Epping to Thornleigh Third Track Proposal. Application number SSI 5132.

Name(s): M & V Levenson

I/we object to the Epping to Thornleigh Third Track Proposal and consider that the EIS is inadequate and does not address the full impact of this proposal. It will cause untold damage to the health of residents and to the fabric of the Beecroft Cheltenham Heritage Conservation Area. Do not approve this project, reconsider the alternatives and protect the community.

Figure 5.6 Cross-section and elevation - New Cheltenham Station concourse building
Note: Indicatively added to future design

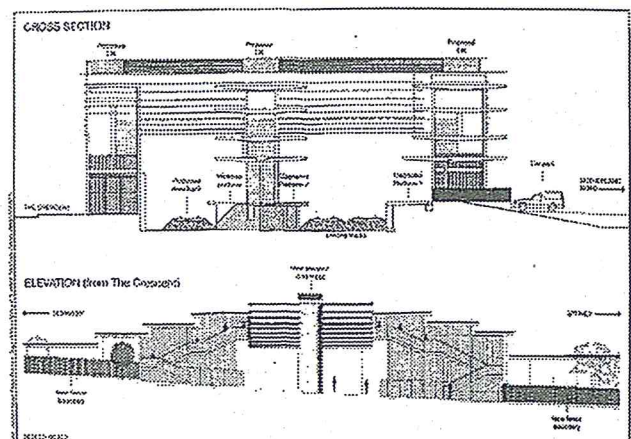
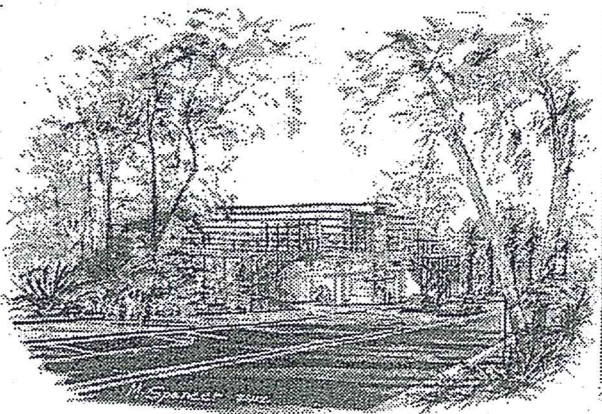
- The proposed redevelopment of Cheltenham Station shows no regard for the HCA. The visual impact of the proposed 13m high glass and steel concourse is totally unacceptable in this HCA.

Concept design drawing of proposed changes to Beecroft Station (Parsons Brinckerhoff 9/3/12). Former side platform shaded in pink.

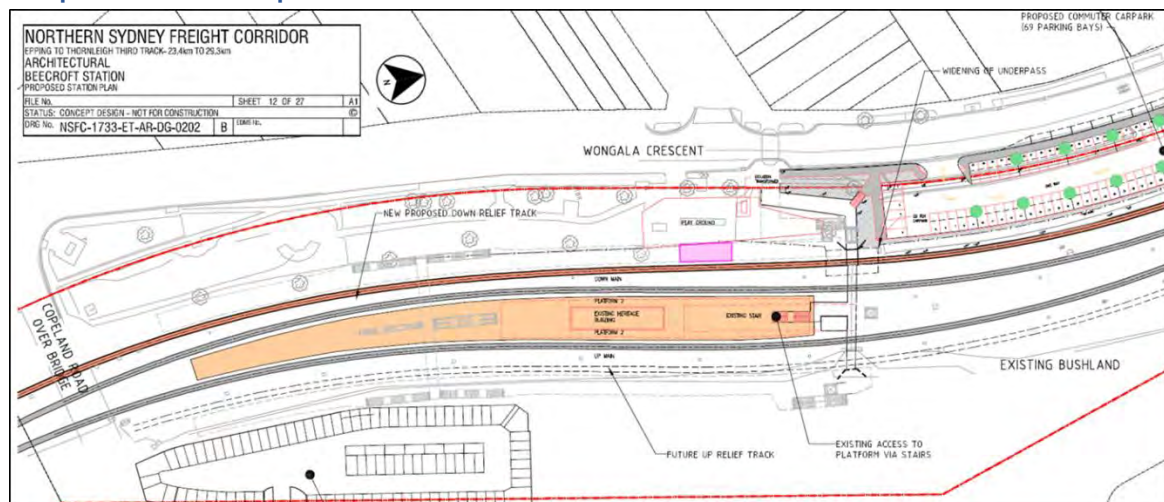
- There has been inadequate assessment of the project's impact on the fabric of the Beecroft Cheltenham Heritage Conservation Area (HCA).
- The plan given for Beecroft Railway station Precinct is vague. The relationship to the trees, playground and original 1895 platform located south of the present station is not shown. A fourth track is shown on the eastern side. The plan does not include urgently needed lifts to allow disabled access at Beecroft Station.

- Beecroft Station Gardens have a heritage listing with Hornsby Council but the impact on them has not been adequately addressed. No arborist's report is given for the trees which will be removed.
